WEST SUSSEX COUNTY COUNCIL CONSULTATION

TO:	Arun District Council FAO: Zac Denton
FROM:	WSCC - Highways Authority
DATE:	21 April 2020
LOCATION:	54 Torton Hill Road Arundel BN18 9HH
SUBJECT:	AB/23/20/HH First floor side/rear extension, porch and canopy to front, single storey rear extension, two storey side/rear extension, external refurbishment to all principle elevations & new permeable paving to drive (resubmission of AB/117/19/HH).
DATE OF SITE VISIT:	n/a
RECOMMENDATION:	Modification
S106 CONTRIBUTION TOTAL:	n/a

Drawing P04 March 2020 Scale 1:250 @ A3
Planning Drawing - Existing & Proposed Site Plan

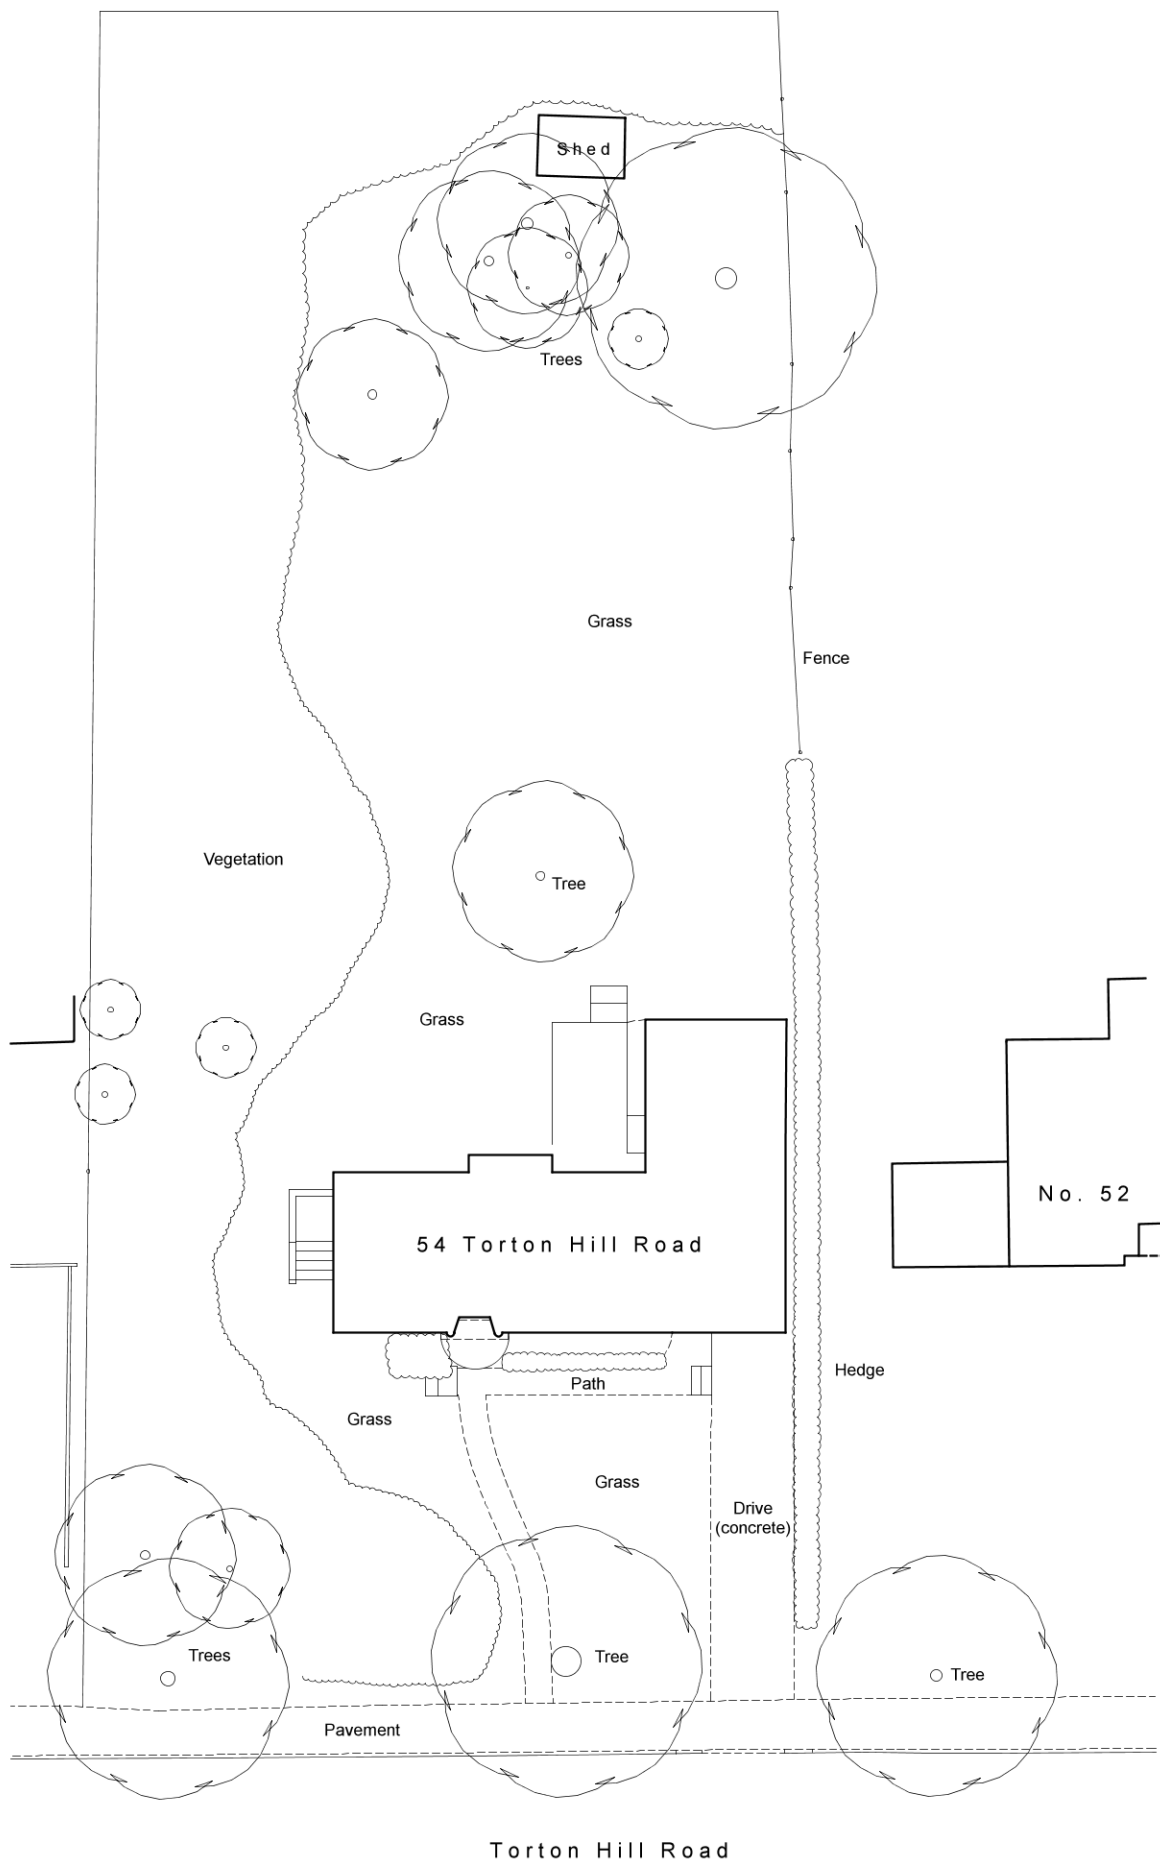
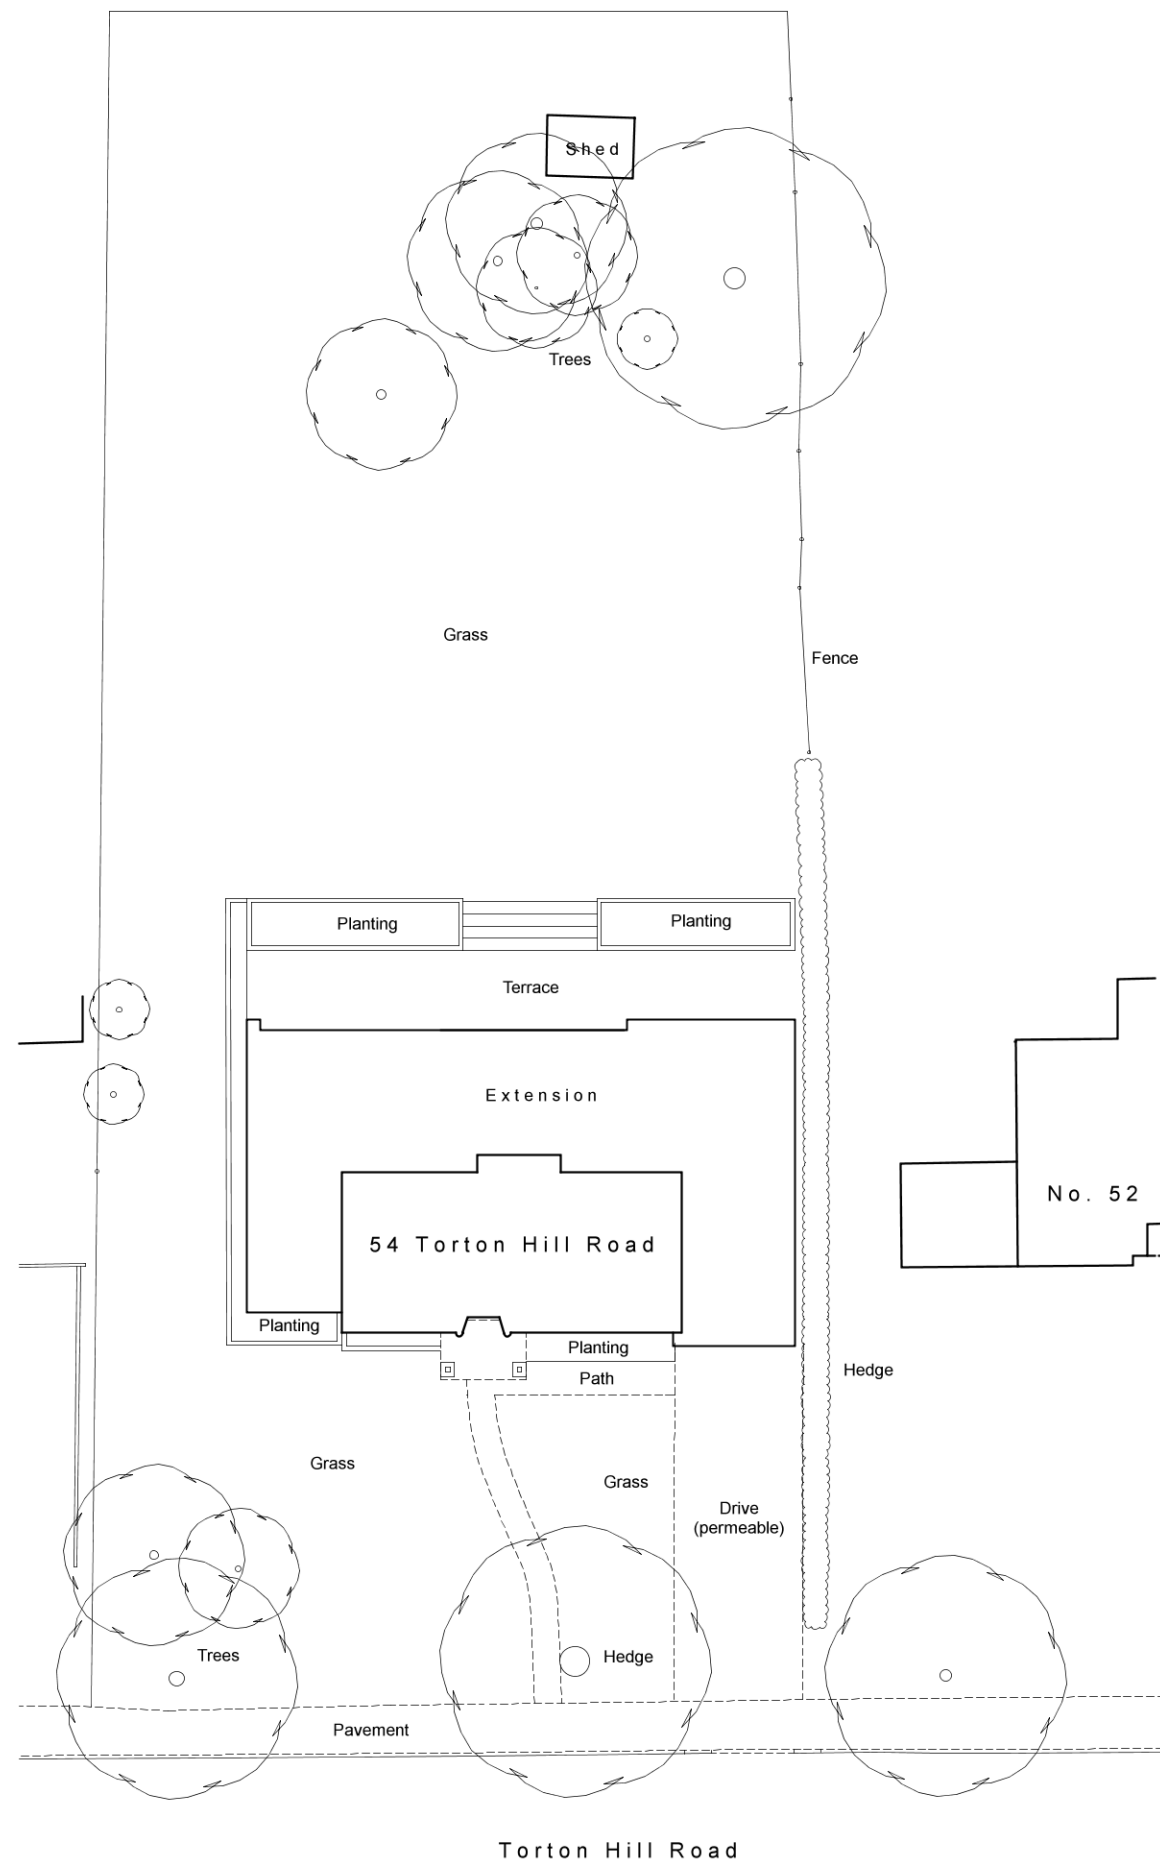
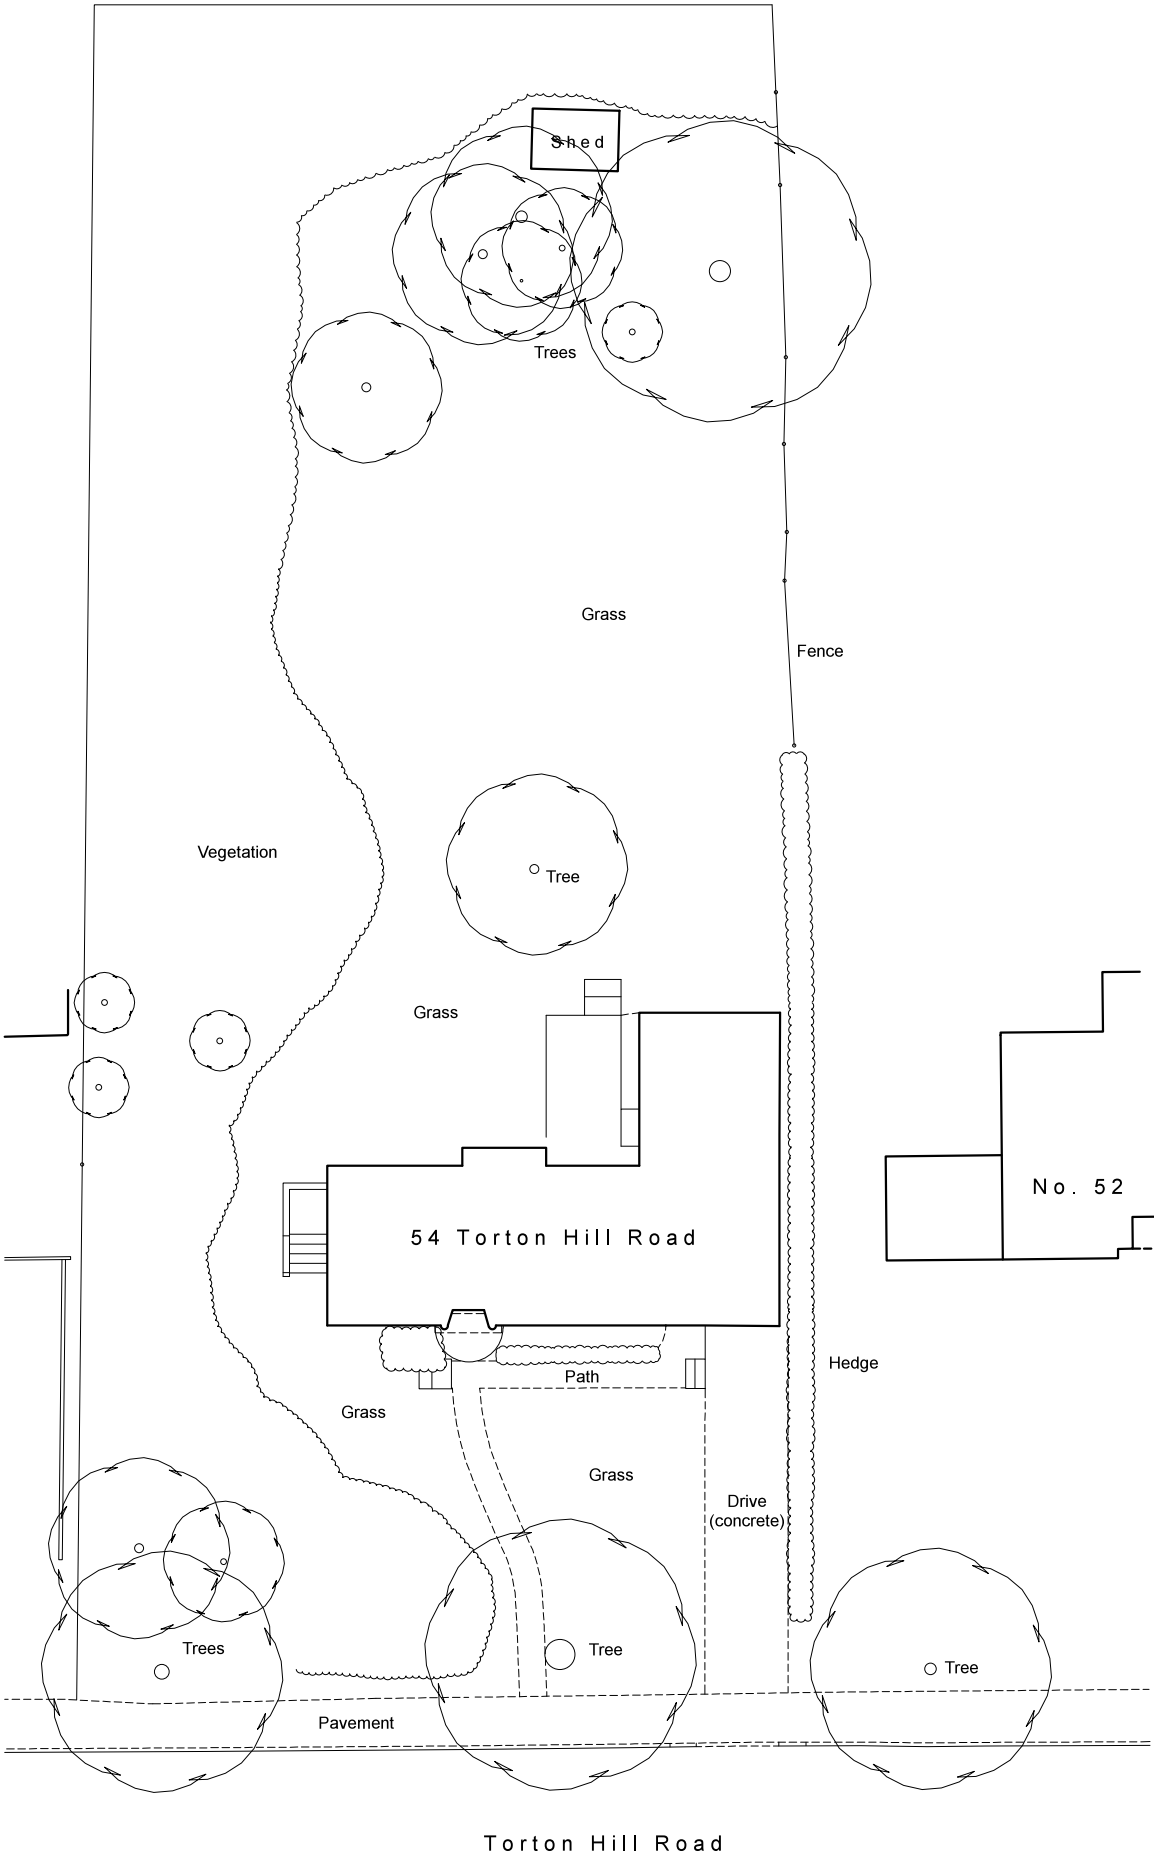
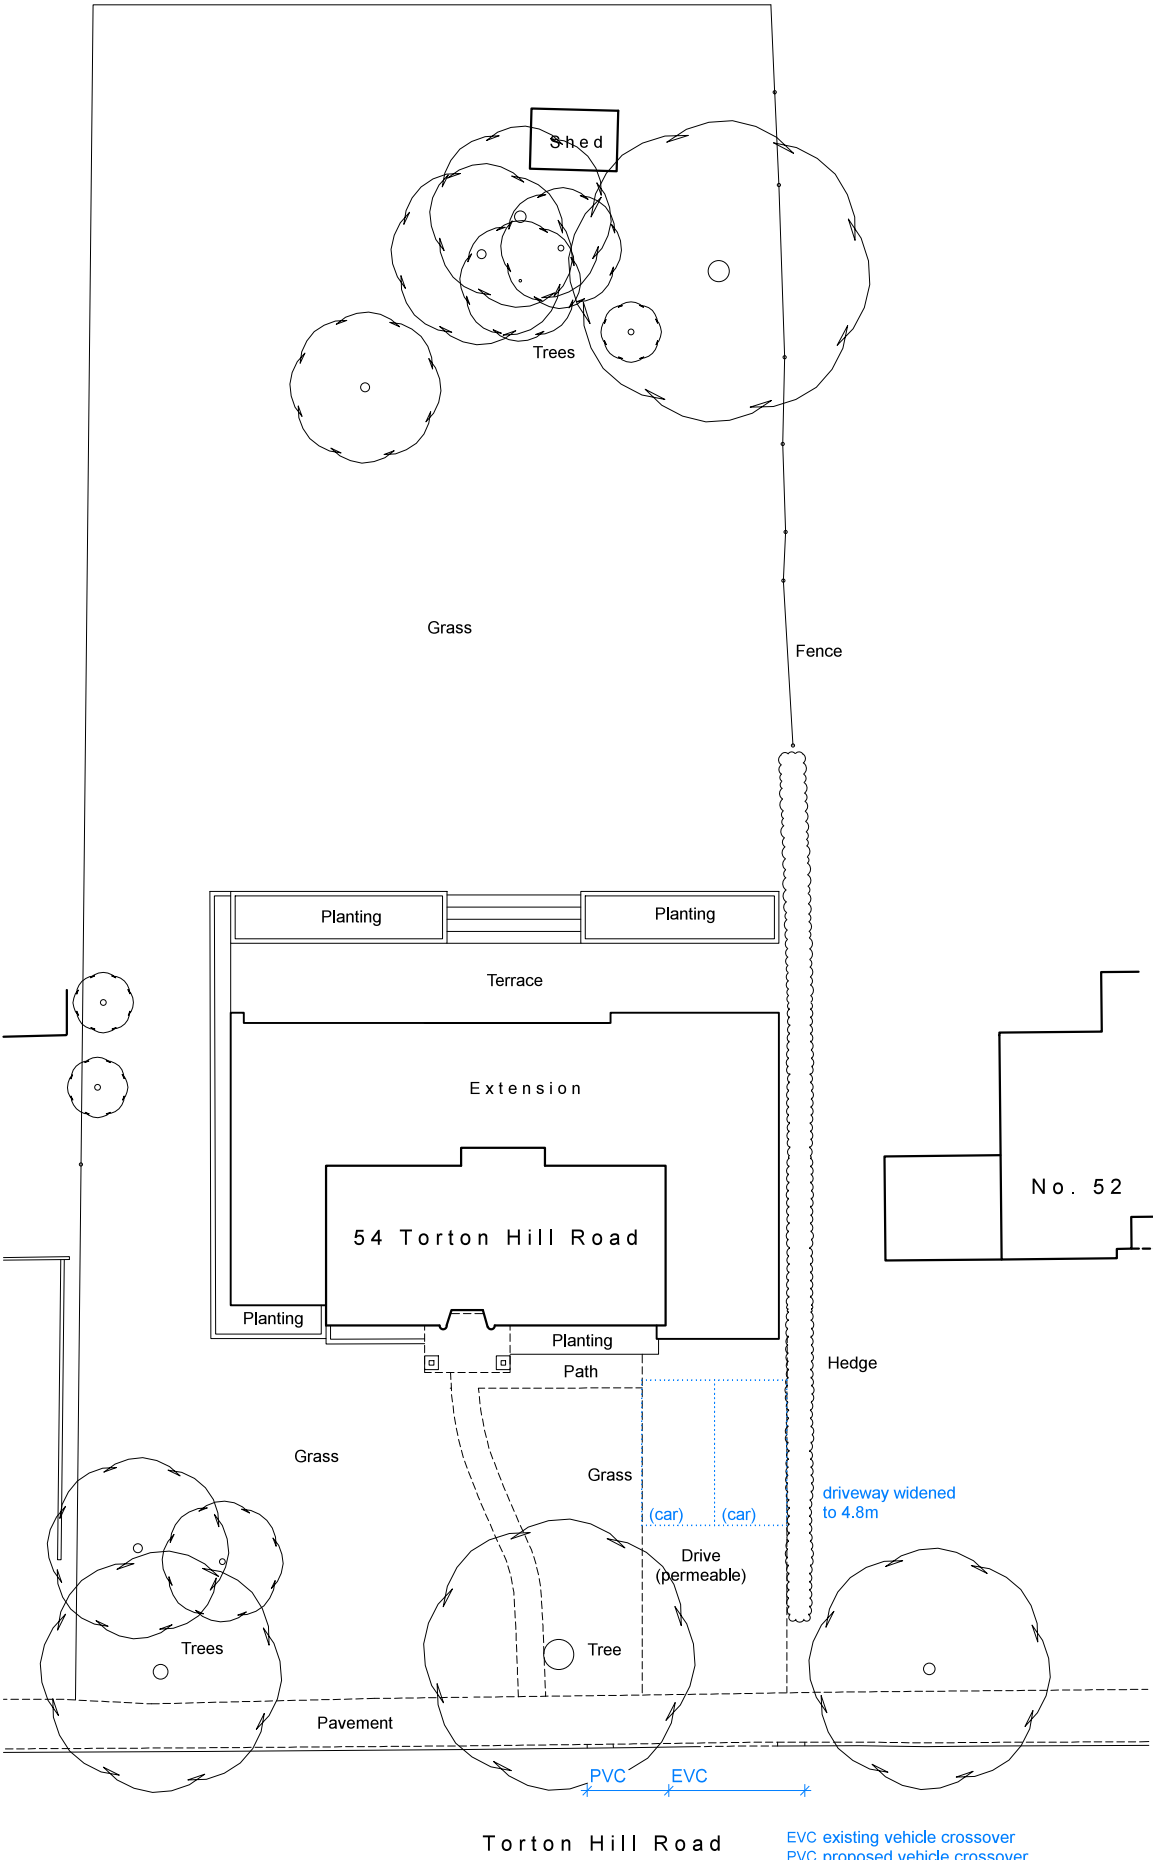
The LHA advises the applicant to widen the Vehicle Crossover (VCO) to accommodate the new hardstanding's width. This should show at least 1 metre both sides to allow a vehicle to enter and exit the parking area without fouling upon the kerb edge.

The proposed hardstanding area measures 4.3 x 11.5 metres. This would provide two parking spaces in tandem. The LHA takes a view on tandem spaces as not being an ideal practice and as such, applicants are advised where possible to provide alternative provisions. The LHA observes on the submitted plans, that the applicant has ample space to extend the parking area's width by 0.5 metres to accommodate this practice.
